City of Portland, Maine - Building or Use Permit Application
 389 Congress Street, 04101 Tel: (207) 874-8703, Fax: (207) 874-8716

Permit No: 04-0502	Issue Date:	CBL: 003 K008001
------------------------------	--------------------	----------------------------

Location of Construction: 38-40 Eastern Promenade Unit B	Owner Name: Chaiklin Rebecca &	Owner Address: 80 Varick St # 9b	Phone: 917-414-1336
Business Name:	Contractor Name:	Contractor Address:	Phone:
Lessee/Buyer's Name	Phone:	Permit Type: Alterations - Multi Family	Zone:

Past Use: 6 unit condominium bldg. still under single ownership: Unit B	Proposed Use: Unit B w/reconfigured floorplan	Permit Fee: \$291.00	Cost of Work: \$30,000.00	CEO District: 1
Proposed Project Description: Reconfigure Unit B floorplan		FIRE DEPT: <input type="checkbox"/> Approved <input type="checkbox"/> Denied	INSPECTION: Use Group: Type	
		Signature:	Signature:	
PEDESTRIAN ACTIVITIES DISTRICT (P.A.D.)				
Action: <input type="checkbox"/> Approved <input type="checkbox"/> Approved w/Condition <input type="checkbox"/> Denied				
Signature: _____ Date: _____

1 FLOOR PLAN #38A
 1/8" = 1'-0"

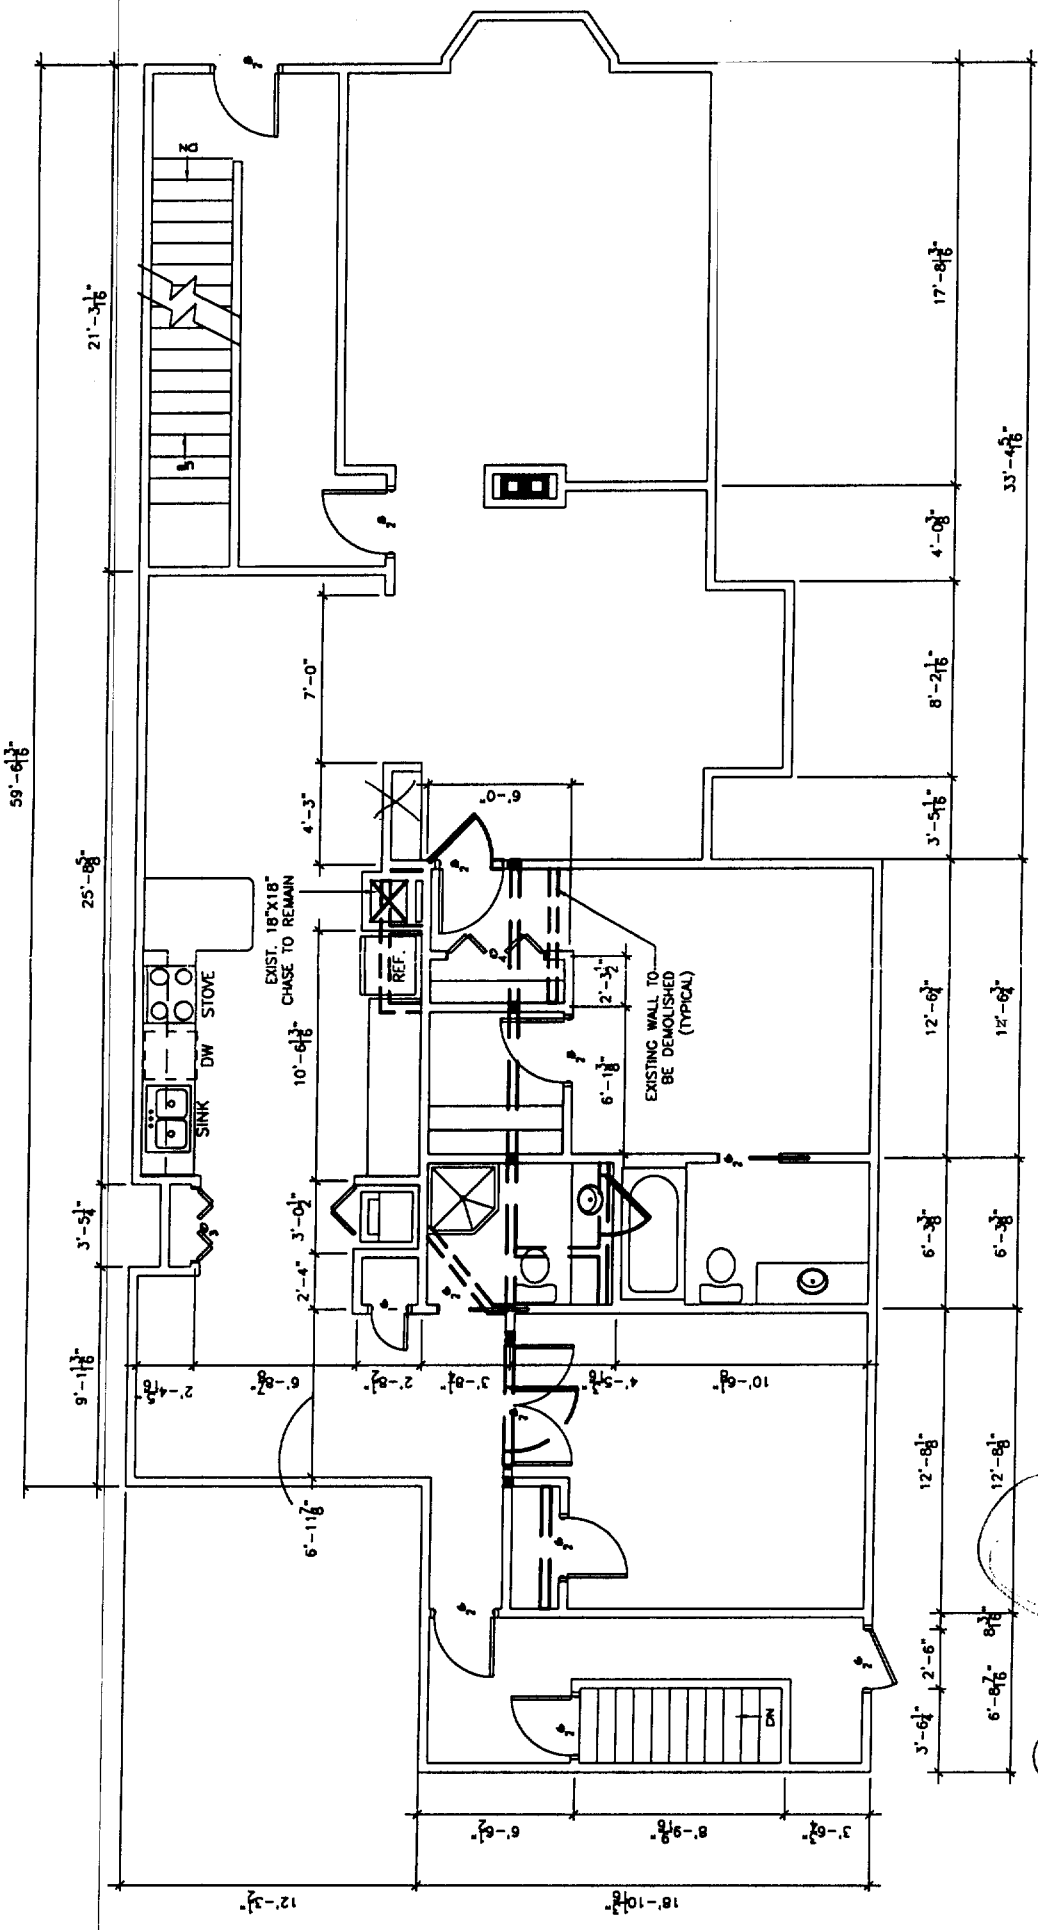
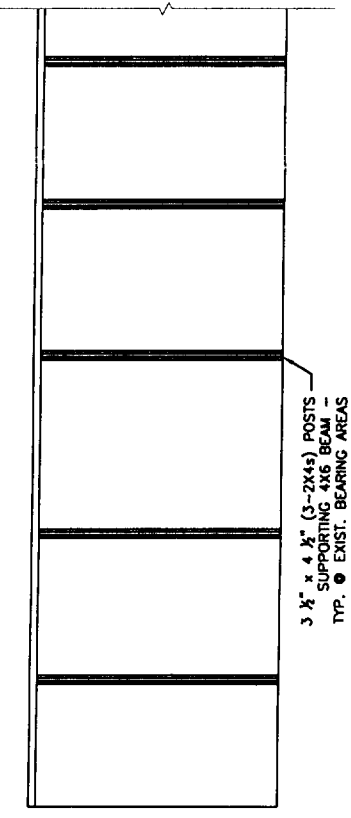
Comments:
05/04/2004-mjn: Cumulative construction cocst \$60,000 plus! Needs a design professional!
